## POST EPC MEMORANDUM

TO: CABQ Development Facilitation Team (DFT)  
FROM: William Steele, Senior Planner  
DATE: 05/05/25  
RE: PR-2025-011387, SI-2025-00040 – Site Plan – EPC

The Agent, Consensus Planning, Inc, for Pulte Group, has worked with Staff to fulfill post EPC requirements to meet Conditions of Approval 1-11, for a Site Plan – EPC, for an approximately 60 acre portion of Tract N-1, Correction Plat of Tracts N-1 & N-2, Watershed Subdivision (AREPL of Tract N Watershed Subdivision), located at 9601 Tierra Pintada Blvd. NW, at the NW corner of Arroyo Vista Blvd. NW and Tierra Pintada Blvd. NW, containing approximately 110 acres. See EPC Notice of Decision (NOD) dated March 20, 2025.

PAGE WAS NOT PART OF ORIGINAL
REVIEWED BY EPC

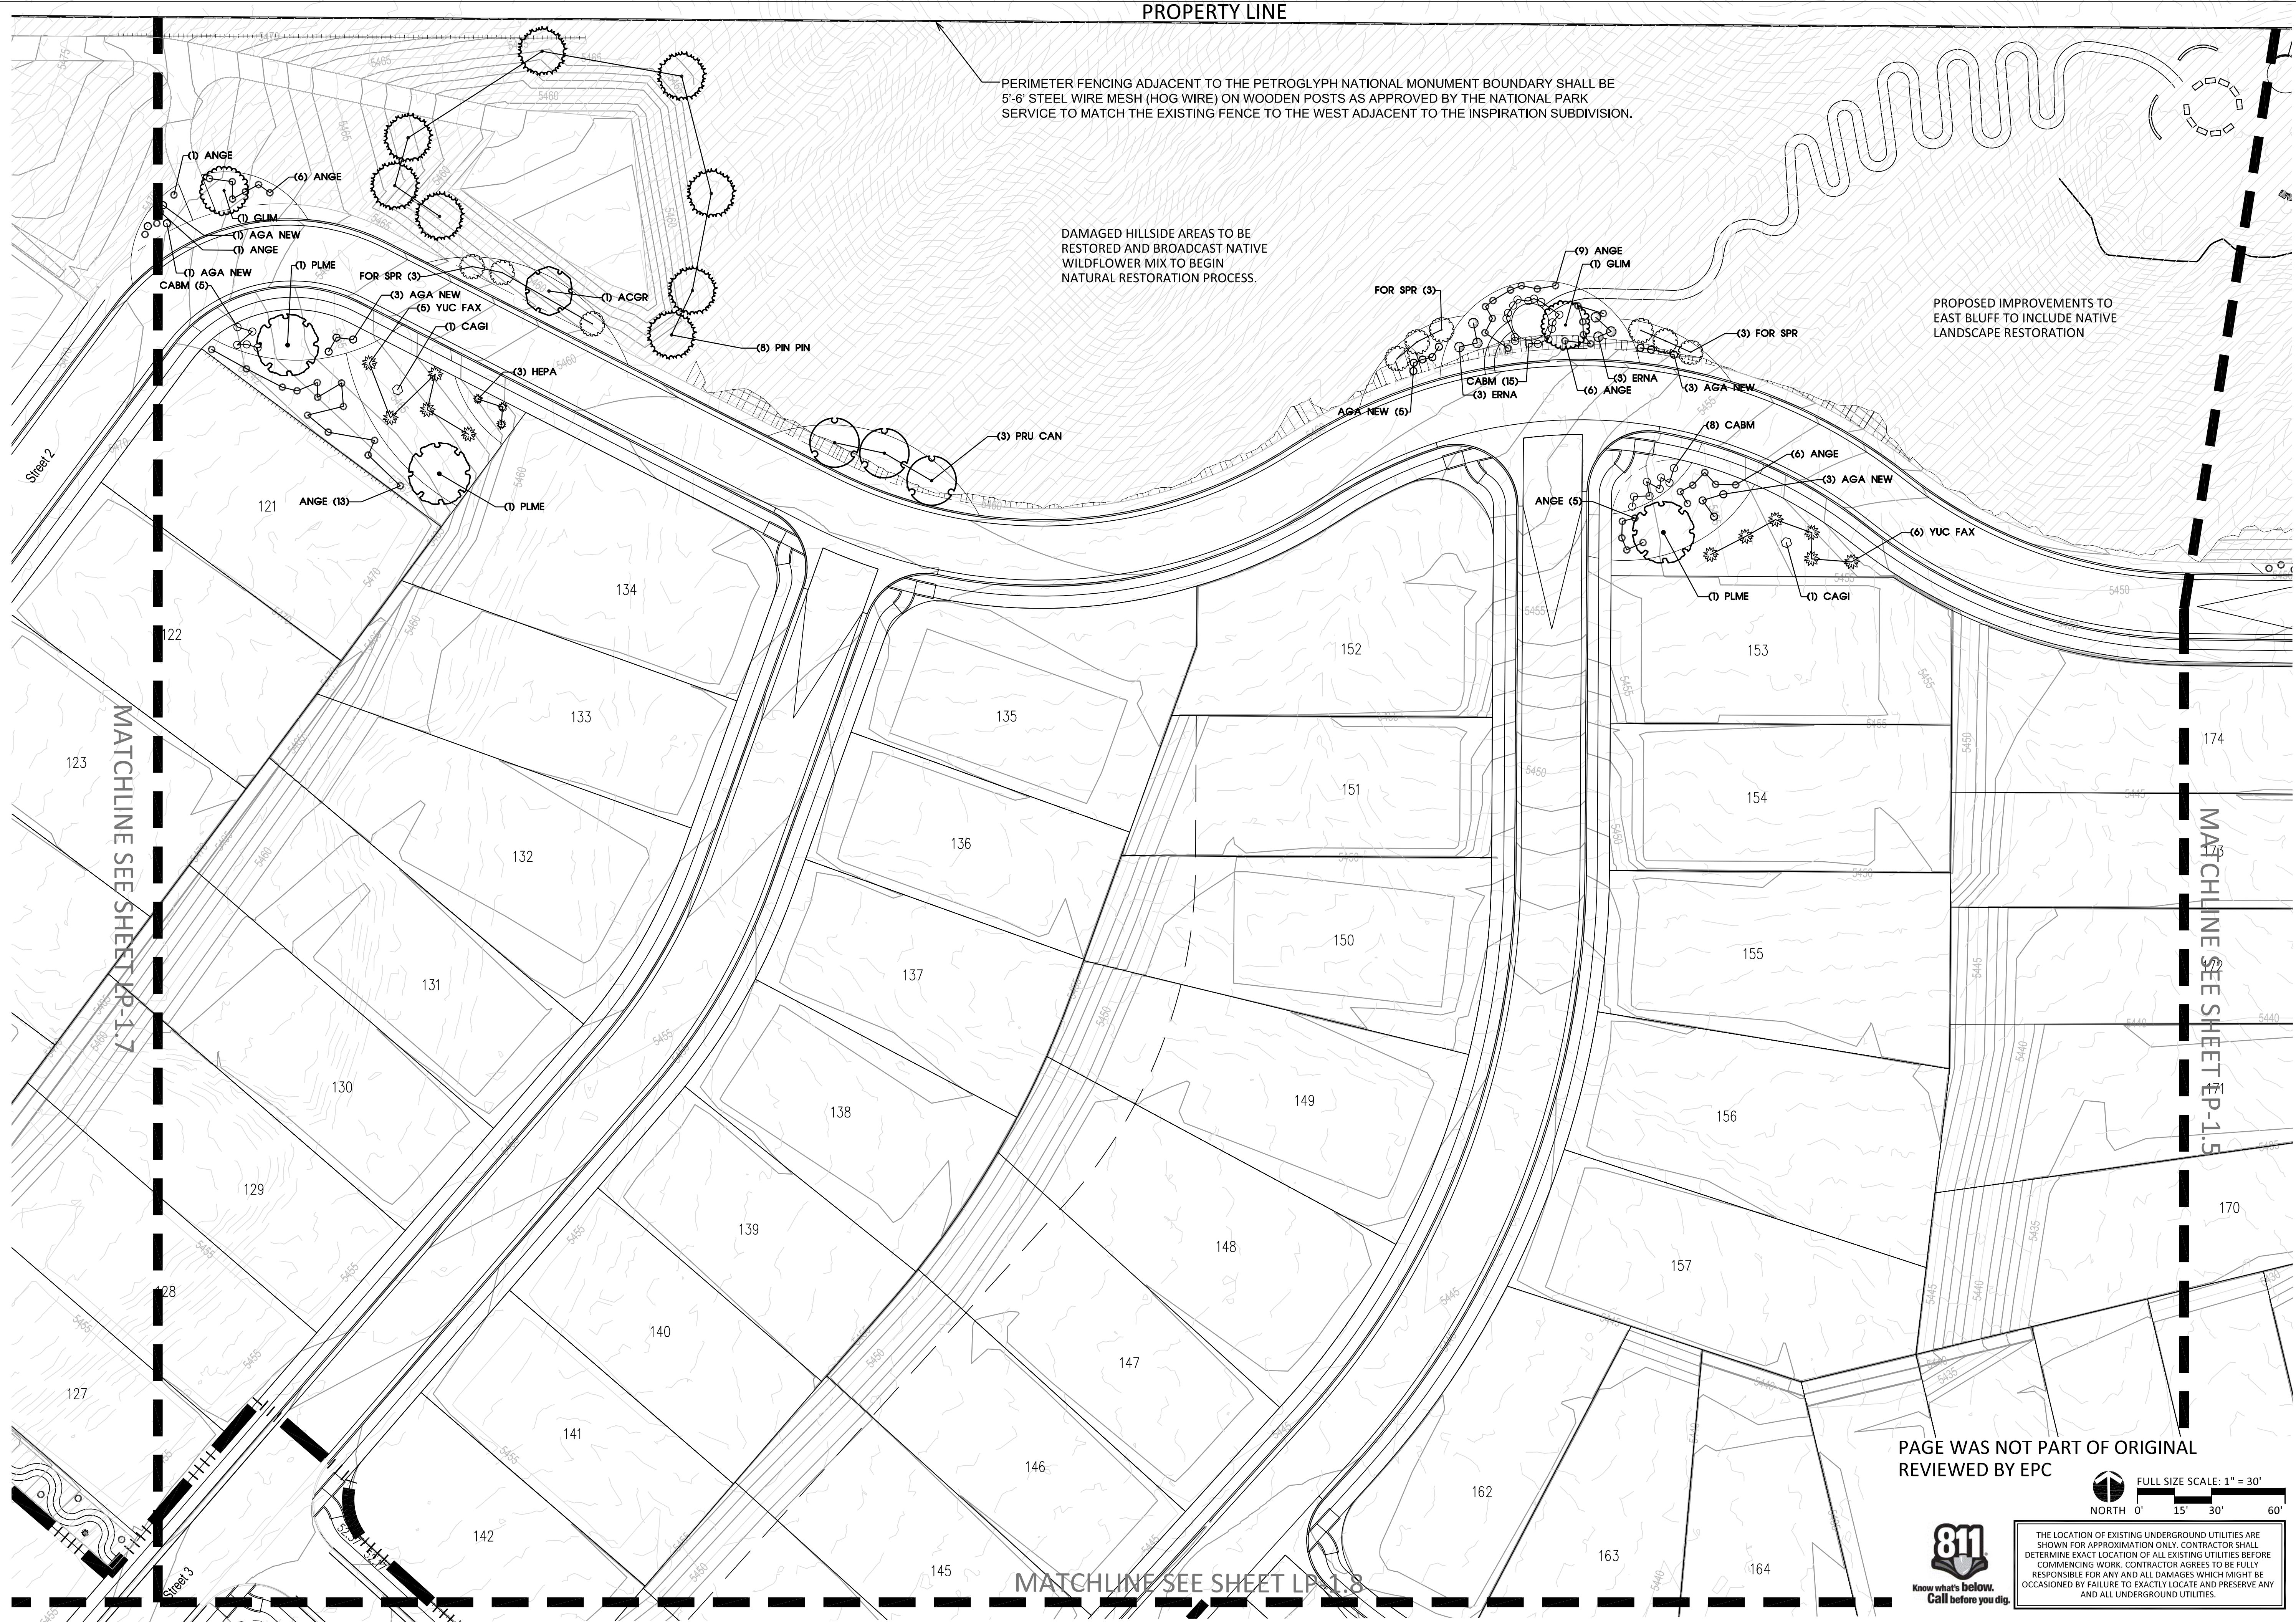
1. The following sheets included in the Post EPC review set were not approved by EPC and will not be reviewed by the Staff Planner as part of EPC's Conditions of Approval in the March, 20, 2024 NOD. These sheets shall be removed from the EPC final sign off set:

- a. PLANTING PLAN sheet
  - b. PROTOTYPICAL DETAILS sheet
  - c. PLANTING PLAN
  - d. PHOTOTYPICAL DETAIL
2. The following sheets were approved by the EPC are missing from the Post EPC drawing set. These shall be submitted to staff for review.

3 PROTOTYPICAL OPEN SPACE / APS FENCE

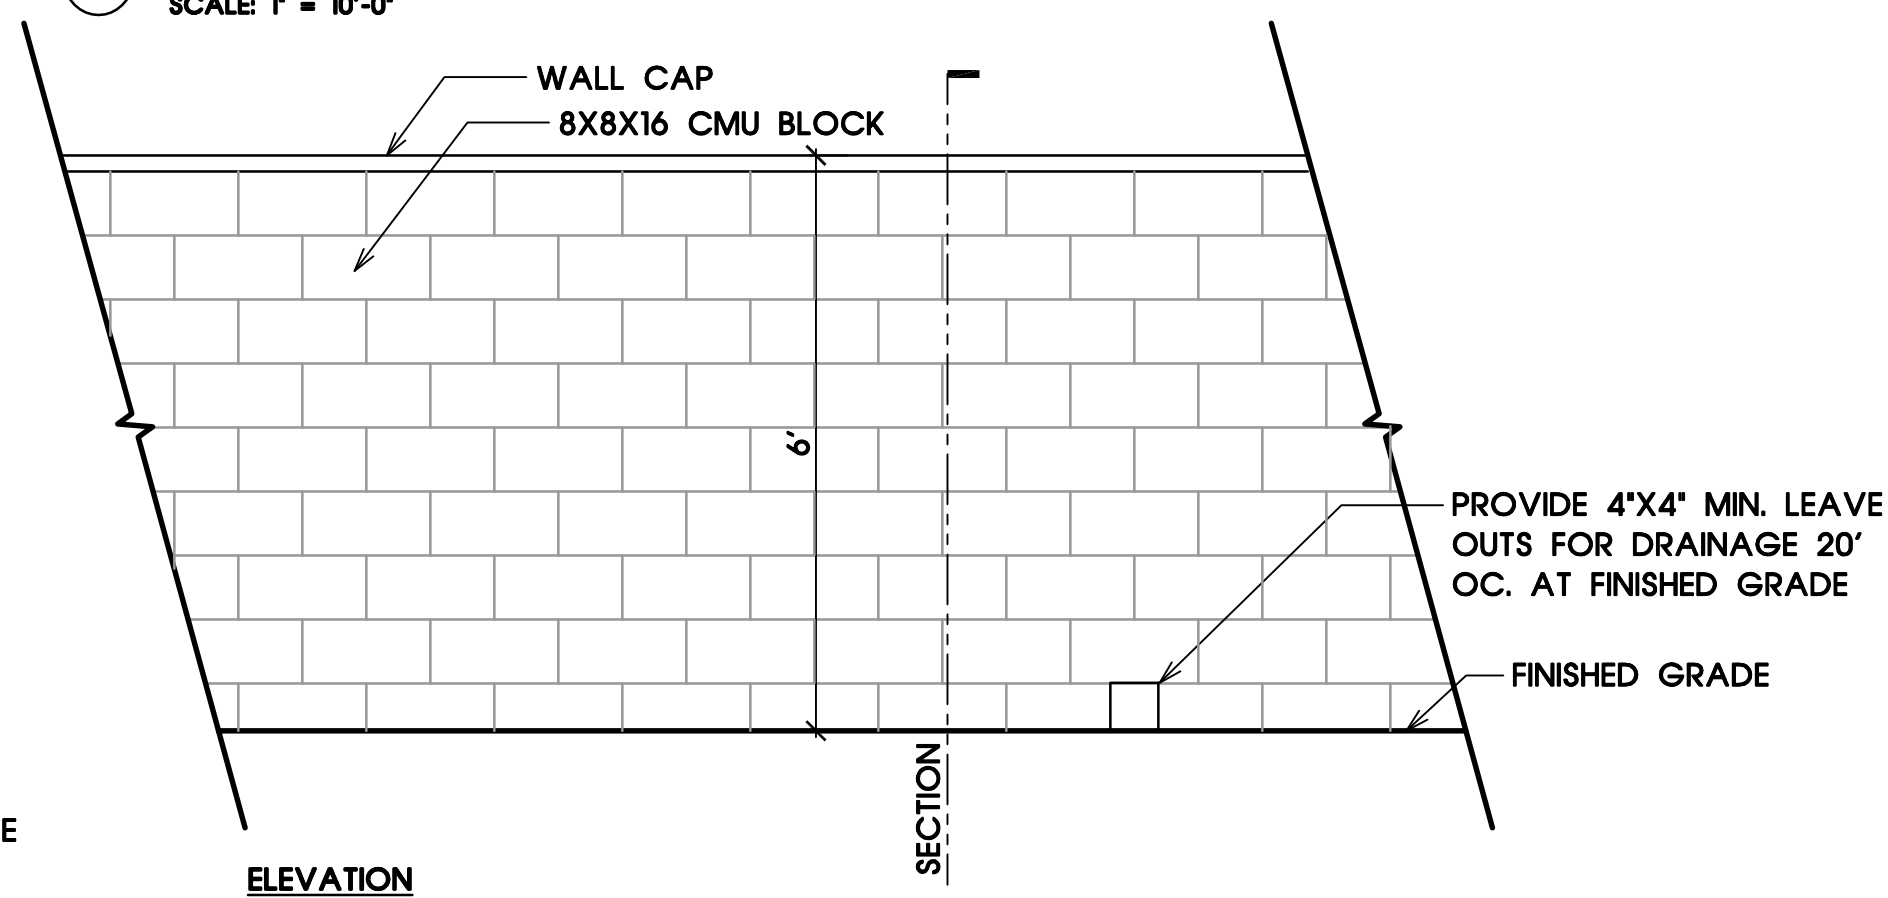
A. A detail of the fencing adjacent to the open space requested by the National Park Service and the wall adjacent to the ABQ Public School shall be provided that notes: perimeter walls adjacent to the open space and APS to be constructed with a lower CMU portion and view fencing on top. The applicant shall work with the National Parks Service on finalizing fence design details along the Monument boundary.

1) *A detail is missing depicting the fencing adjacent to the open space. Please add this detail.*

2) *A detail is missing of the wall adjacent to ABQ Public School. Please add this detail.*
